Kirklees Council
Via E-mail
2 January 2019

PLANNING APPLICATION REF: 2018/91661

PROPOSED RESIDENTIAL DEVELOPMENT - OUTLINE APPLICATION FOR UP TO 74 DWELLINGS WITH MEANS OF ACCESS TO, BUT NOT WITHIN, THE SITE

Drawing Title: Proposed Site Plan

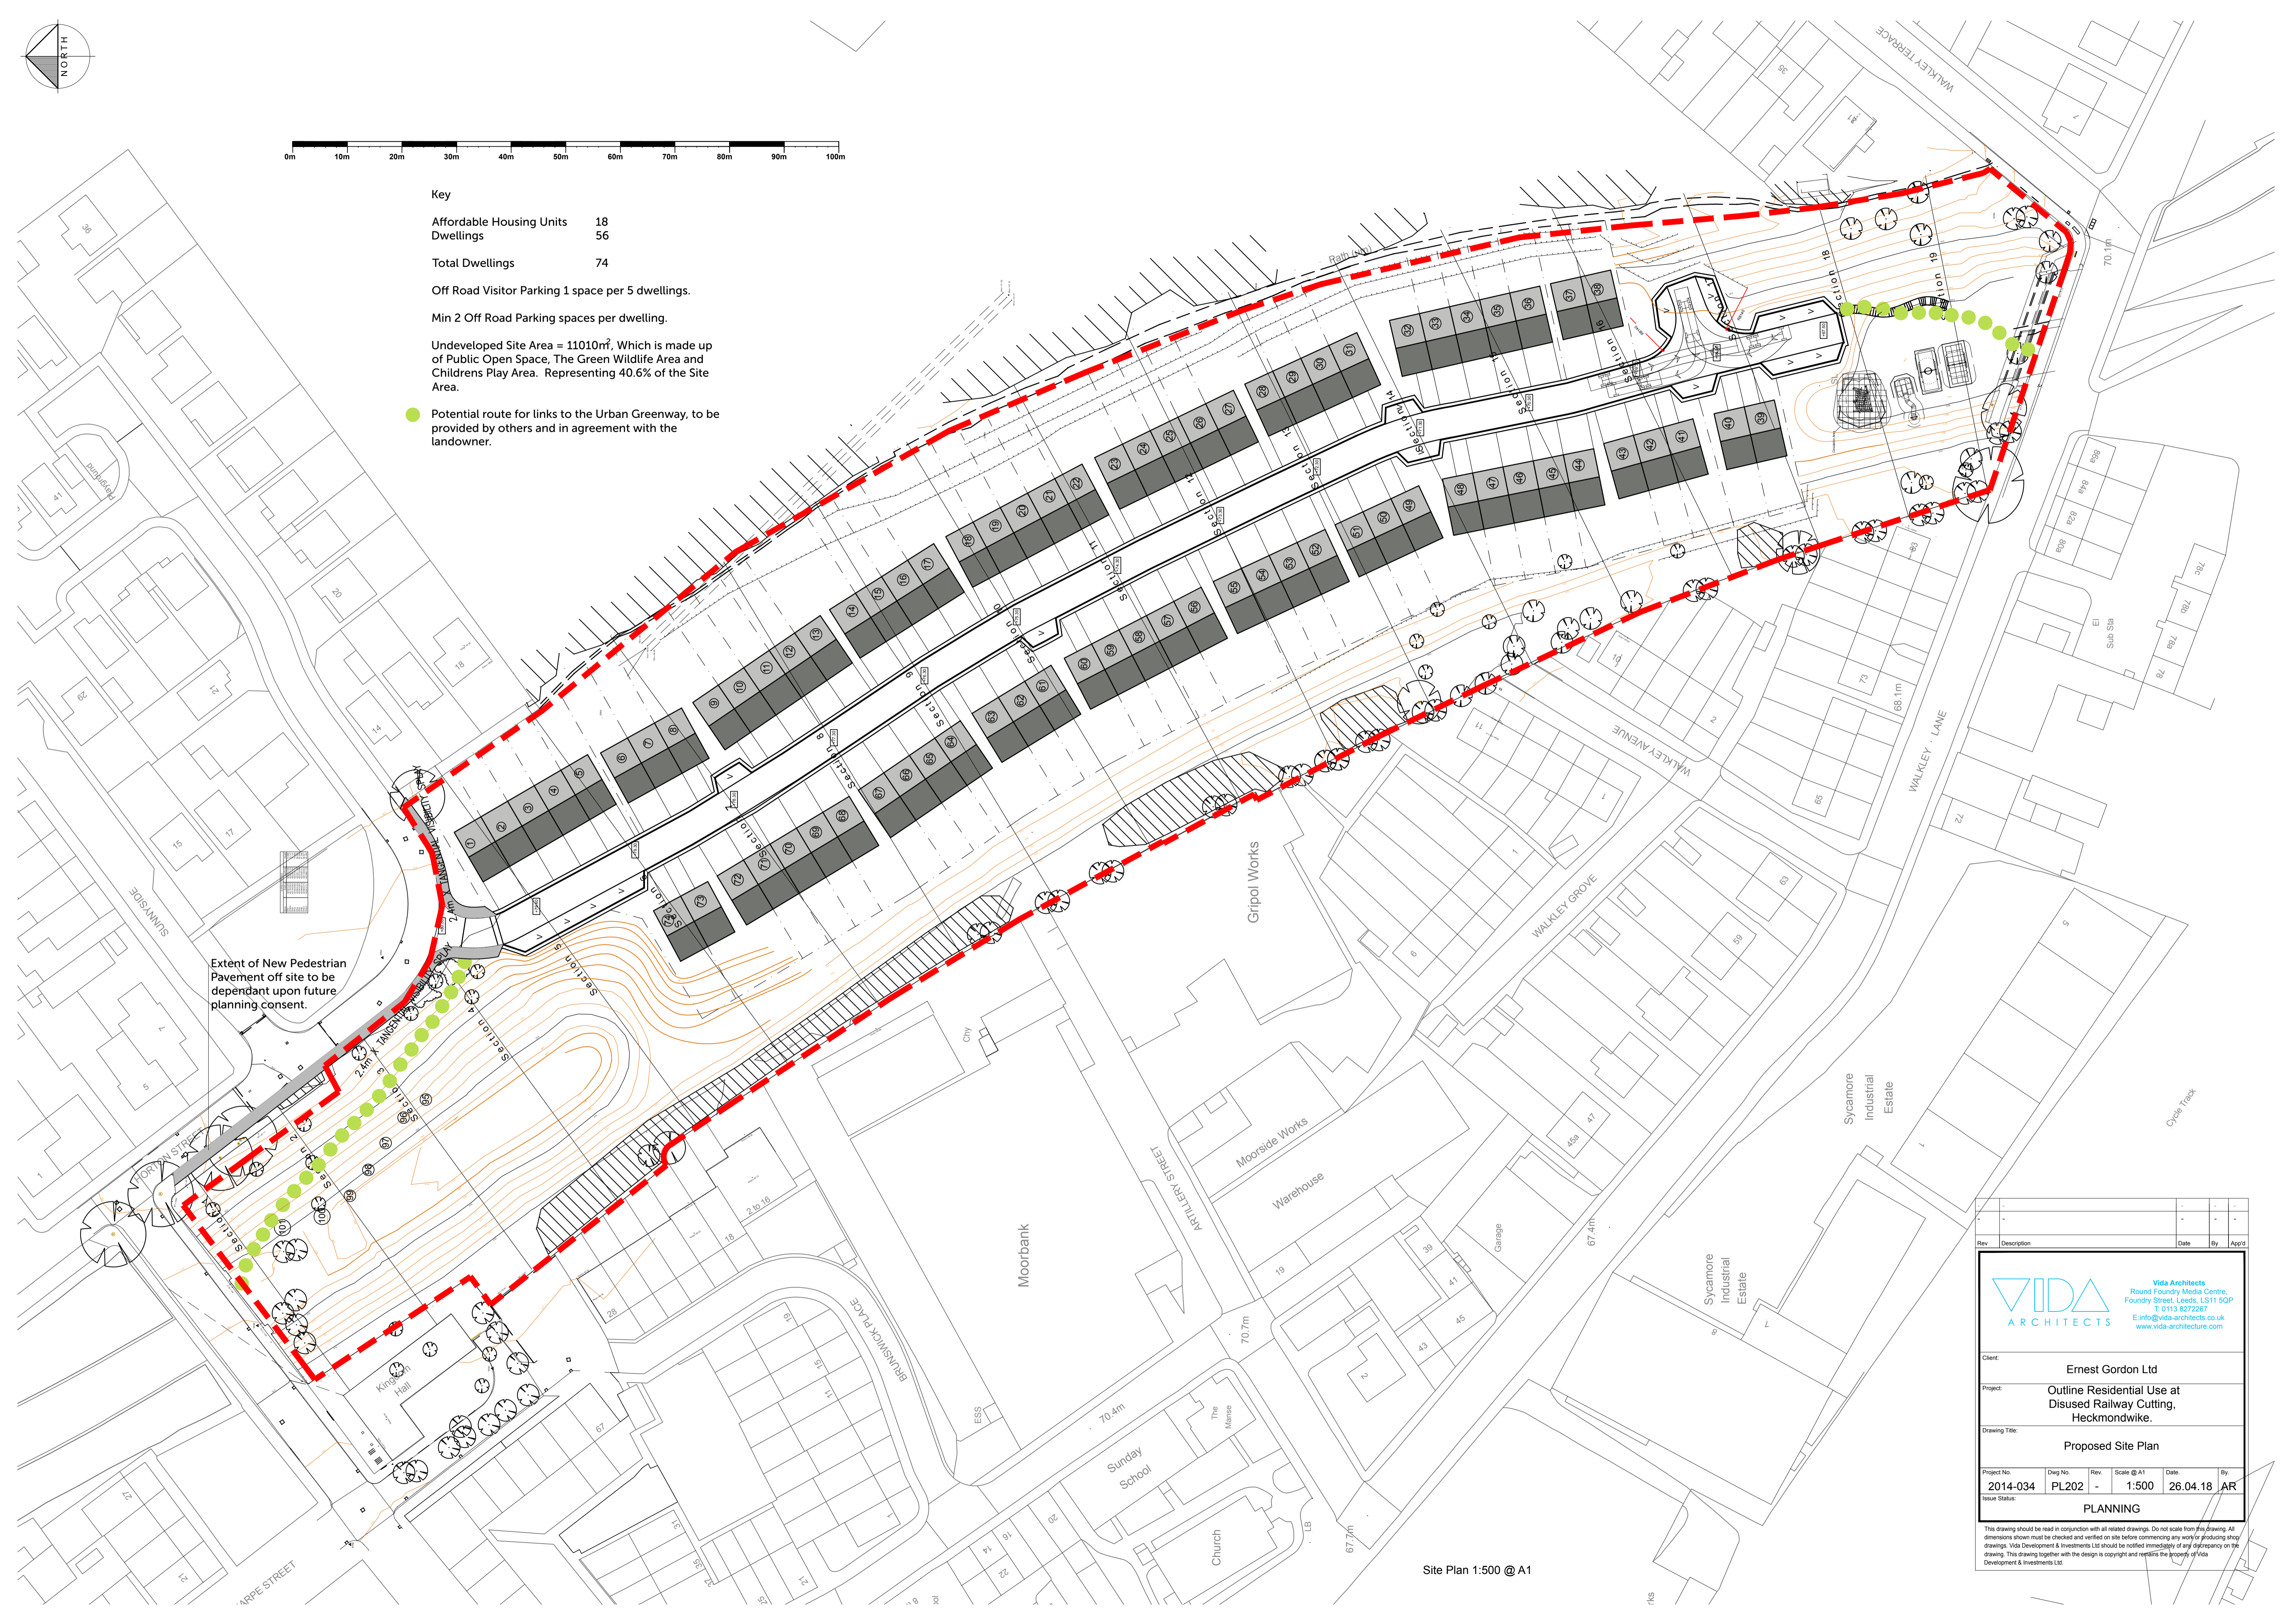
We note that the layout plans in the Transport Statement shows a potential route to link the Spen Valley Ringway though the site. The plans show a 'Potential route for links to the Urban Greenway, to be provided by others and in agreement with the landowner'. We suggest that the council should seek an assurance through a planning condition or obligation that this aspect of the scheme will be implemented to ensure that a continuous link is retained should the Spen Valley Ringway be brought back into use for recreational purposes.
